CLEAR VIEW INDUSTRIAL PARK, FILING 2A

GRADING, STORM AND EROSION CONTROL PLANS

C:\Temp\CV\CAD\Grad\5 GRADING - Pond Details.dwg, 5/25/2020 11:41:45 AM, DWG To PDF.pc3

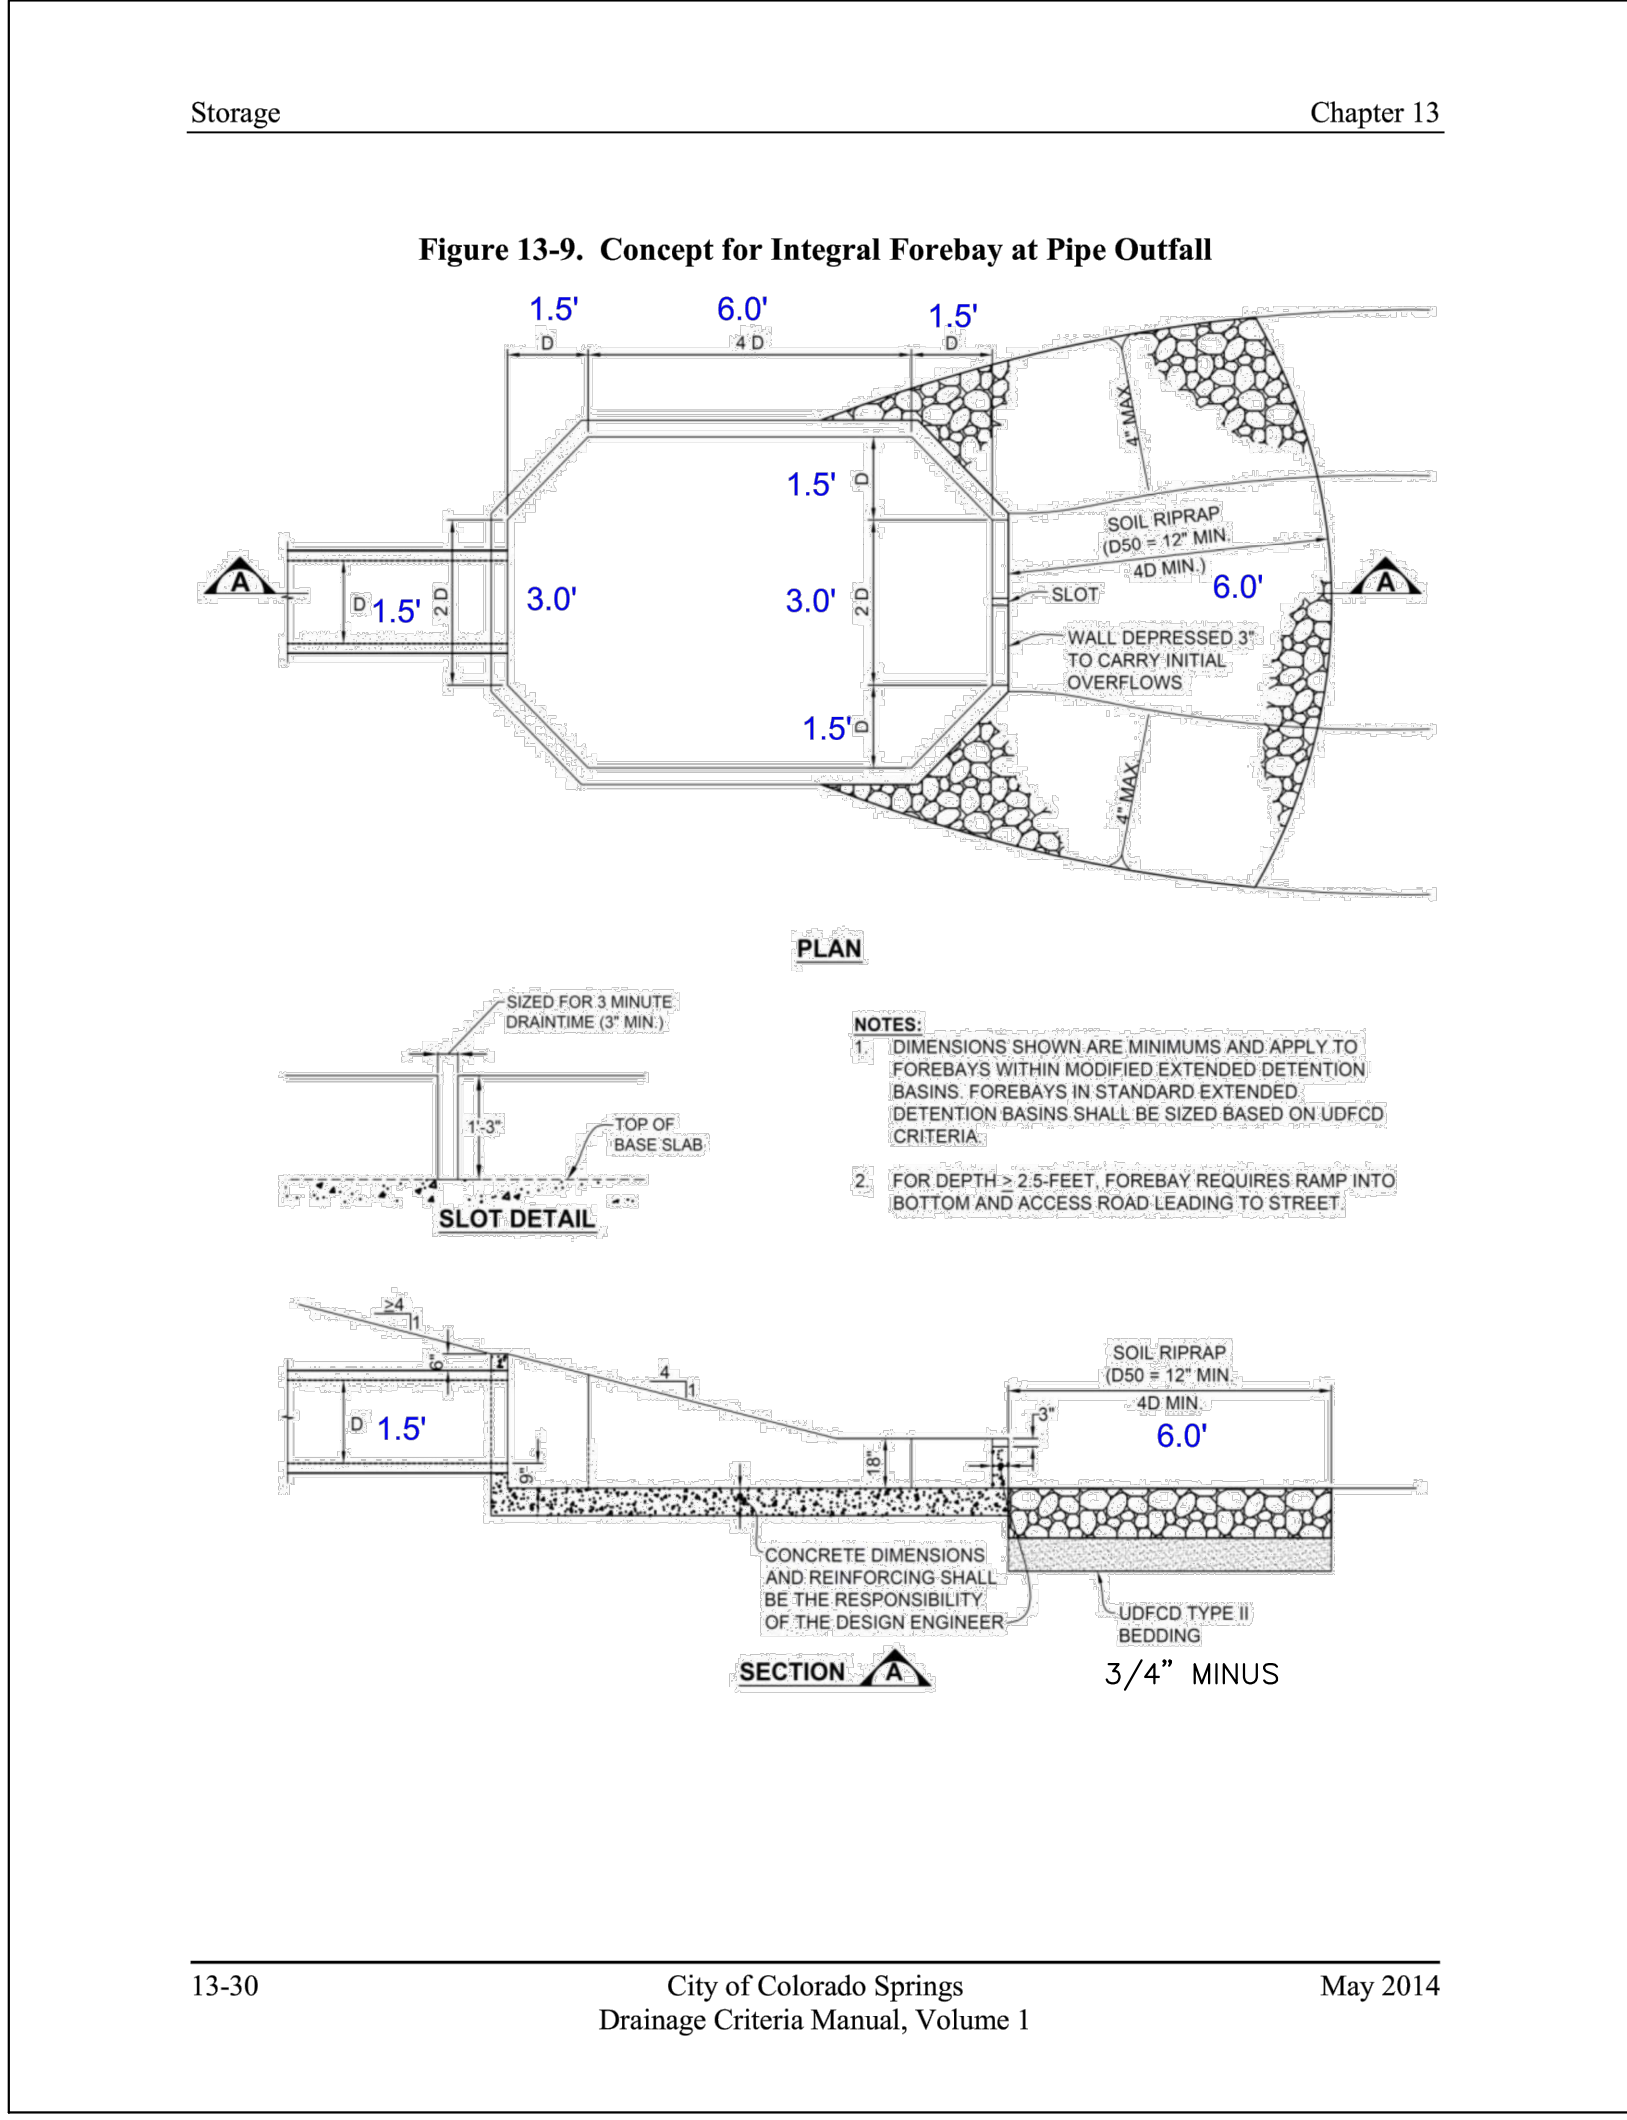
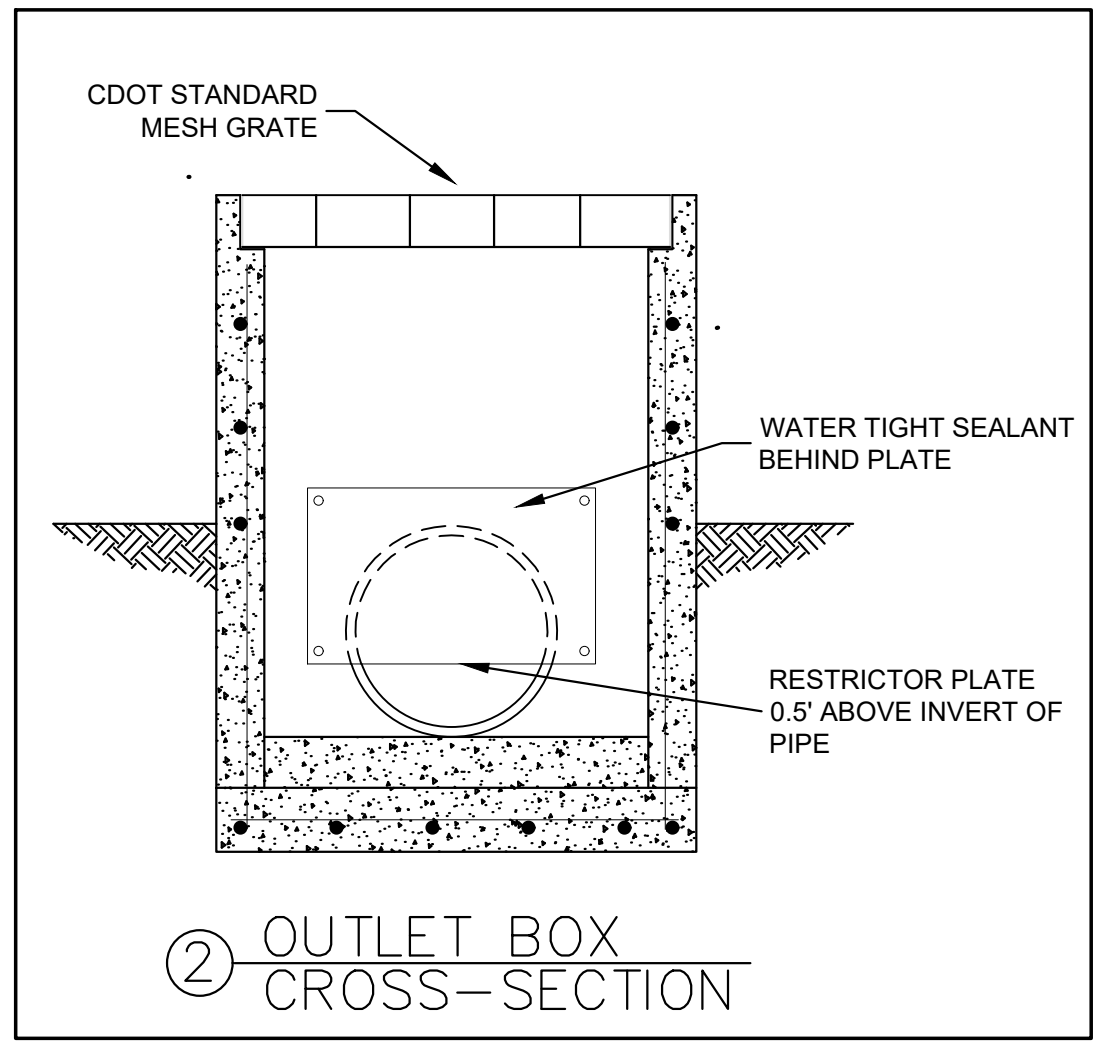
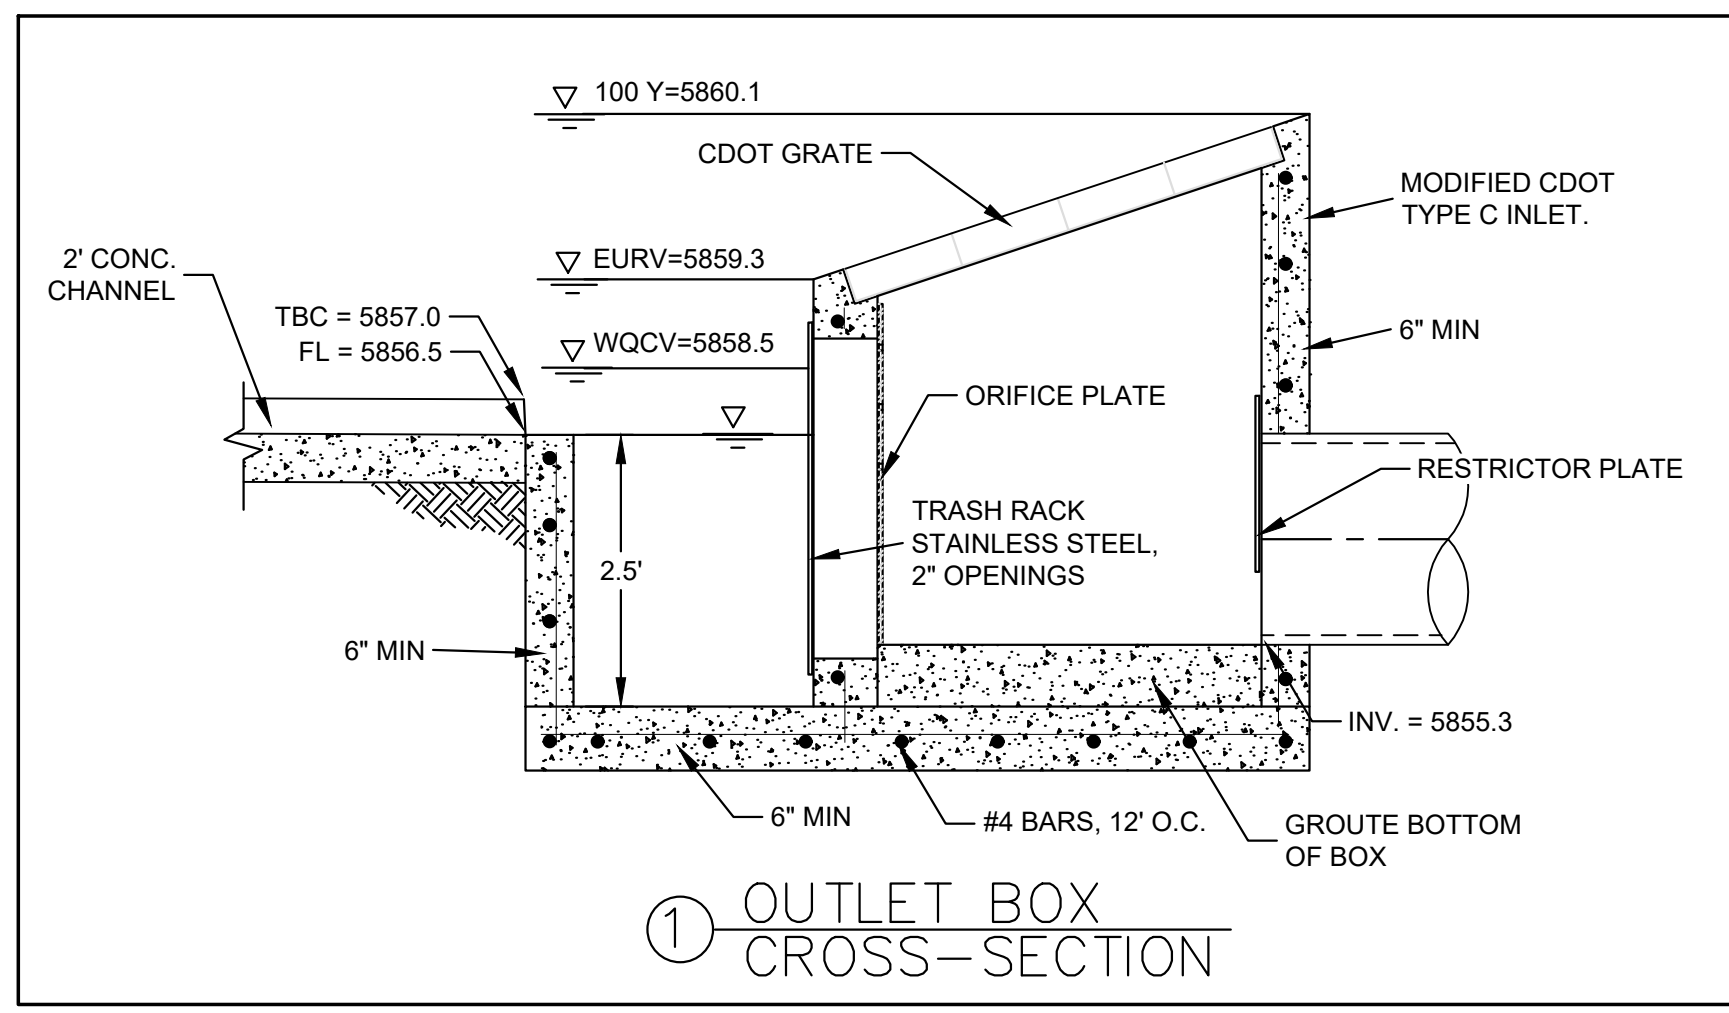
- NOTE:**
- 1) PROVIDE DETAIL FOR HOW THE GRATE IS SECURED. INSIDE OF THE OUTLET STRUCTURE MUST BE ACCESSIBLE FOR MAINTENANCE.
 - 2) PROVIDE DIMENSION FOR RESTRICTOR PLATE TO INCLUDE PLATE THICKNESS.

Revise. Acceptable are either a No. 93 Johnson Vee Wire Stainless Steel Well screen or AMICO KLEMP SR Series Aluminum Bar Grate or approved equivalent. See snippet above.

Provide the section detail of the trash rack proposed.

Provide section detail for how the trash rack and orifice plate is attached. is attached to the outlet structure. See MHFD Vol 3 Chapter 4 Figure OS-5 and OS-6 for an example.

Remove grouted bottom. Design for maintenance. The grout would prevent the orifice plate from being removed & replaced in the future.
